Rezoning Transportation Analysis

Petition Number: 2025-031

General Location Identifier: 04711202, 04711206

The petition is located at the intersection of Neal Road, a City-maintained arterial, and IBM Drive, a City-maintained arterial. The petition is located in a northeast wedge inside of Route 4

RZ-1.0

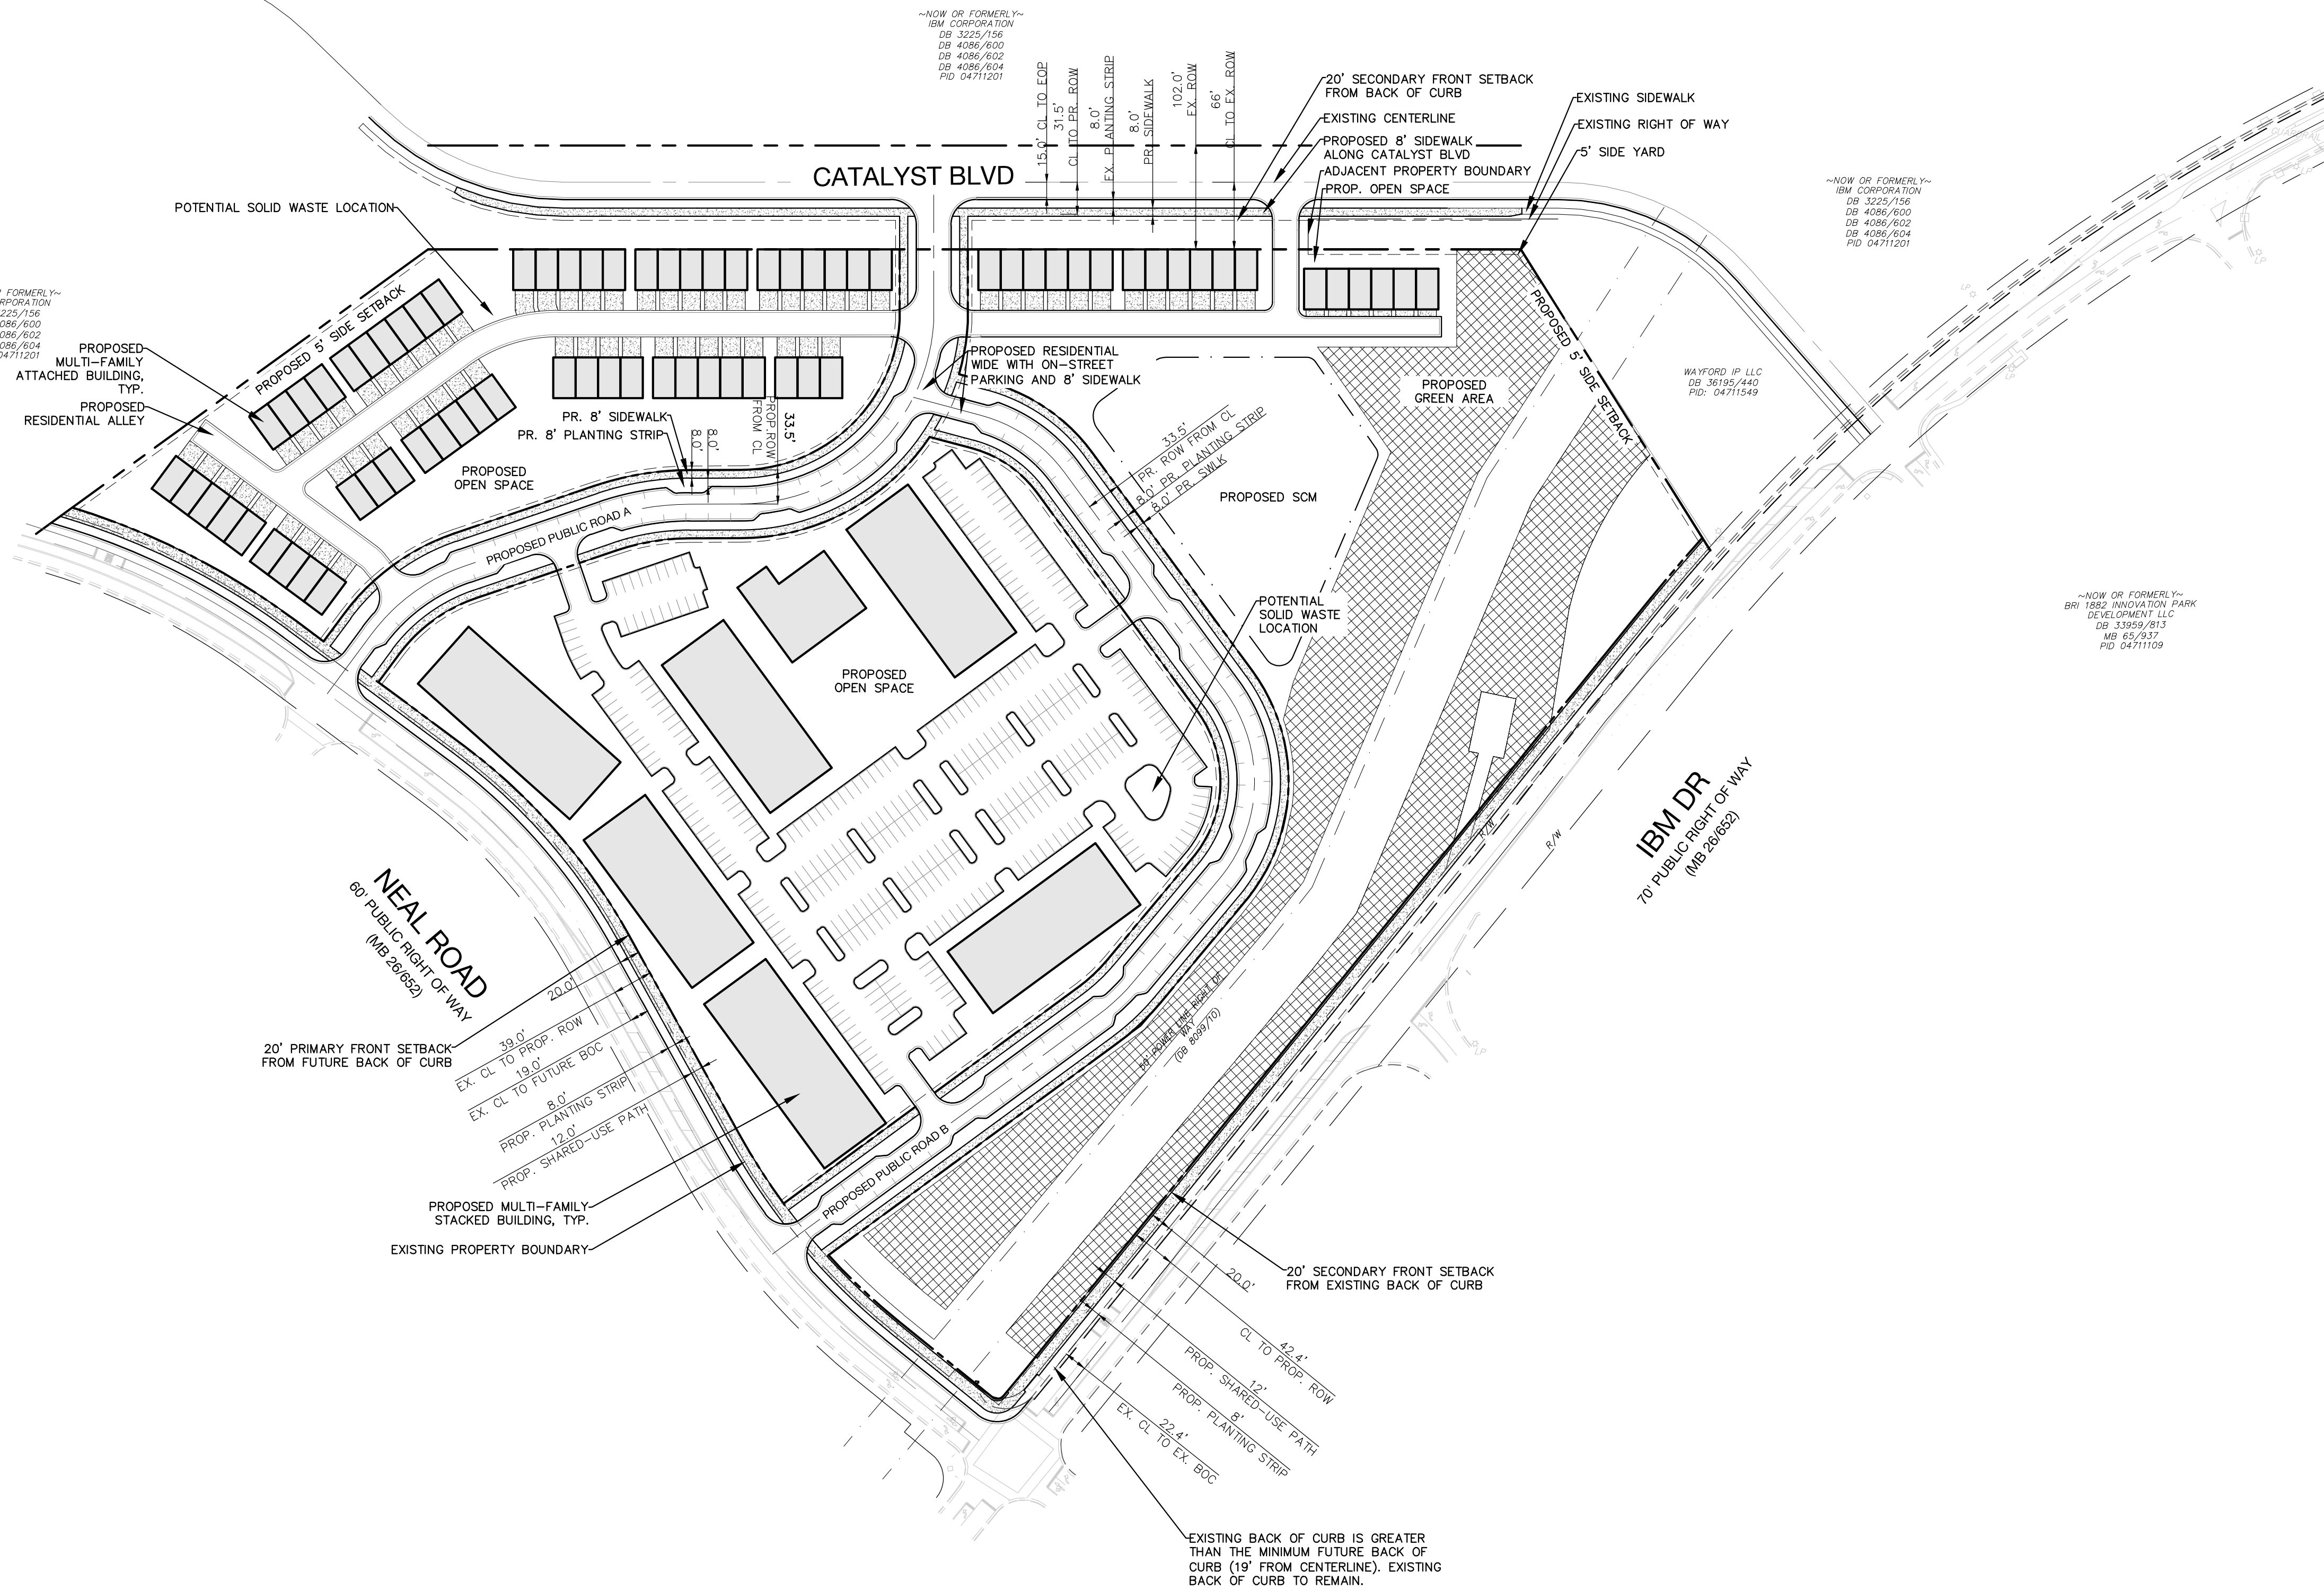
5. ~~Outstanding Comment 5-19-2025:~~ Revise site plan and conditional note(s) to commit to revising site plan to match previously approved street network from rezoning 2020-102 including the access point on IBM in coordination with Subdivision. Site plan shall label and dimension each road to meet CLDSM standard detail U-03.

6. ~~Outstanding Comment from 04-23-25:~~ Revise site plan and conditional note(s) to add sidewalk on all internal street networks. Sidewalk to be a min of 8 feet wide per UDO table 33-4. Site plan shall label, and dimension from the roadway centerline.

7. ~~Outstanding Comment from 04-23-25:~~ Revise site plan and conditional note(s) to add sidewalk along Catalyst Drive meeting UDO requirement of 8 feet wide and an 8-foot planting strip. Site plan shall label, and dimension each from the roadway centerline.

8. ~~Outstanding Comment from 04-23-25:~~ Revise site plan and conditional note(s) to commit to construct bicycle facilities by installing a 12' multi-use path in accordance with the council-adopted Charlotte Streets Map along Neal Road and IBM Drive frontages. Multi-use paths maintained by the City shall meet ADA/PROWAG requirements.

- Clarifying Comment 05-21-25:** Add a conditional note committing to the construction and placement of the SUP along Neal Road and IBM Drive frontages.

11. **CDOT REQUEST from 10-23-25:** Add conditional note to provide a minimum of 50' feet of ROW from the centerline of IBM Drive to accommodate the future right turn lane. Some of the ROW can be placed in an SUE. This ROW will allow for a right turn lane to be constructed at the signal which will drastically increase the functionality of the intersection.
